Application for a Non-Material Amendment Following a Grant of Planning Permission

Erection of single storey side and first floor side extensions. Internal alterations including conversion of garage to habitable room. Alterations to fenestrations. Alterations to front garden landscaping.

23/02923/HOU

The proposed installation of a photovoltaic solar panel array on the roof of the approved first floor side extension and associated alteration to the roof slope of the approved mono-pitch first floor side extension roof.

SECTIONS AS PROPOSED	02.06B
8 Lord Chancellor Walk Kingston upon Thames KT2 7HG	2307.P
for 	1:100 @ A3
Steven Pollock Architects © 	02/24

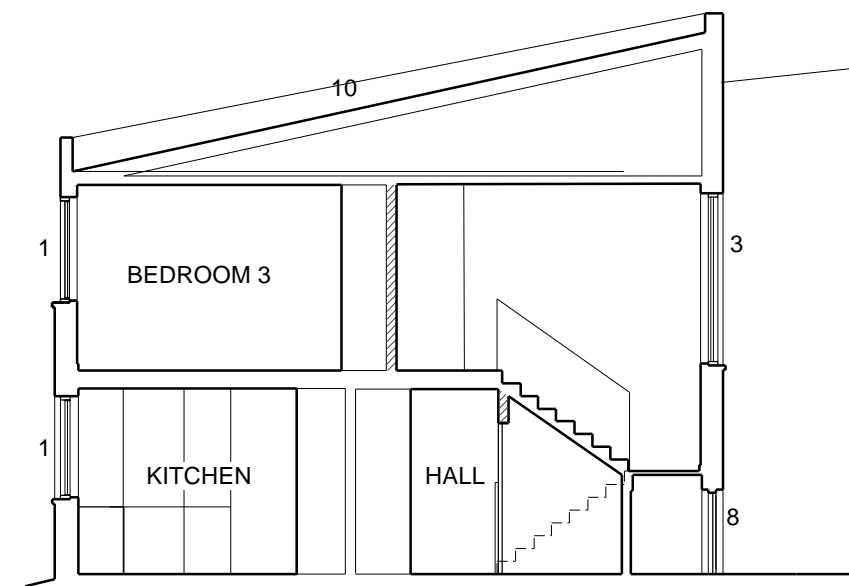
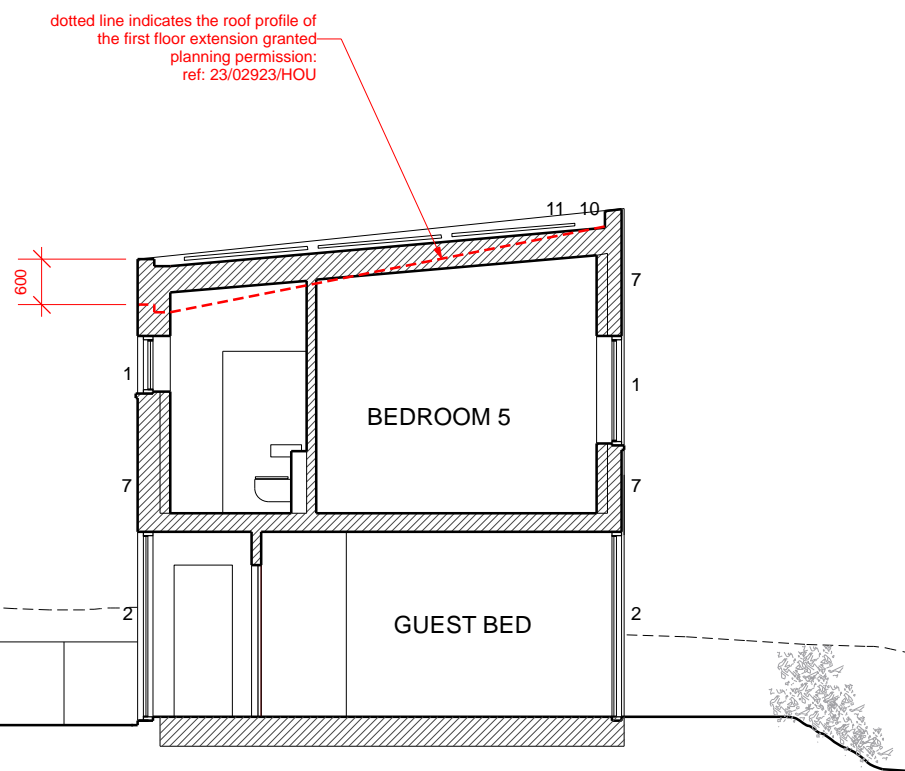
The north facing mono-pitch roof of the approved first floor side extension slopes at approximately 11 degrees from horizontal. The maximum slope for the photovoltaic solar panels on a north facing roof is 5 degrees.

Changing the pitch of the roof to accommodate the photovoltaic panels will increase the height of the approved first floor side extension rear (north) elevation by 600 mm. The flank (east) elevation will increase in height but this will vary from 0 mm at the front to 600 mm at the rear. The height of the front elevation remains unaltered and as approved.

2307.P/02.04B - Roof plan as proposed
2307.P/02.05B - Elevations as proposed
2307.P/02.06B - Sections as proposed
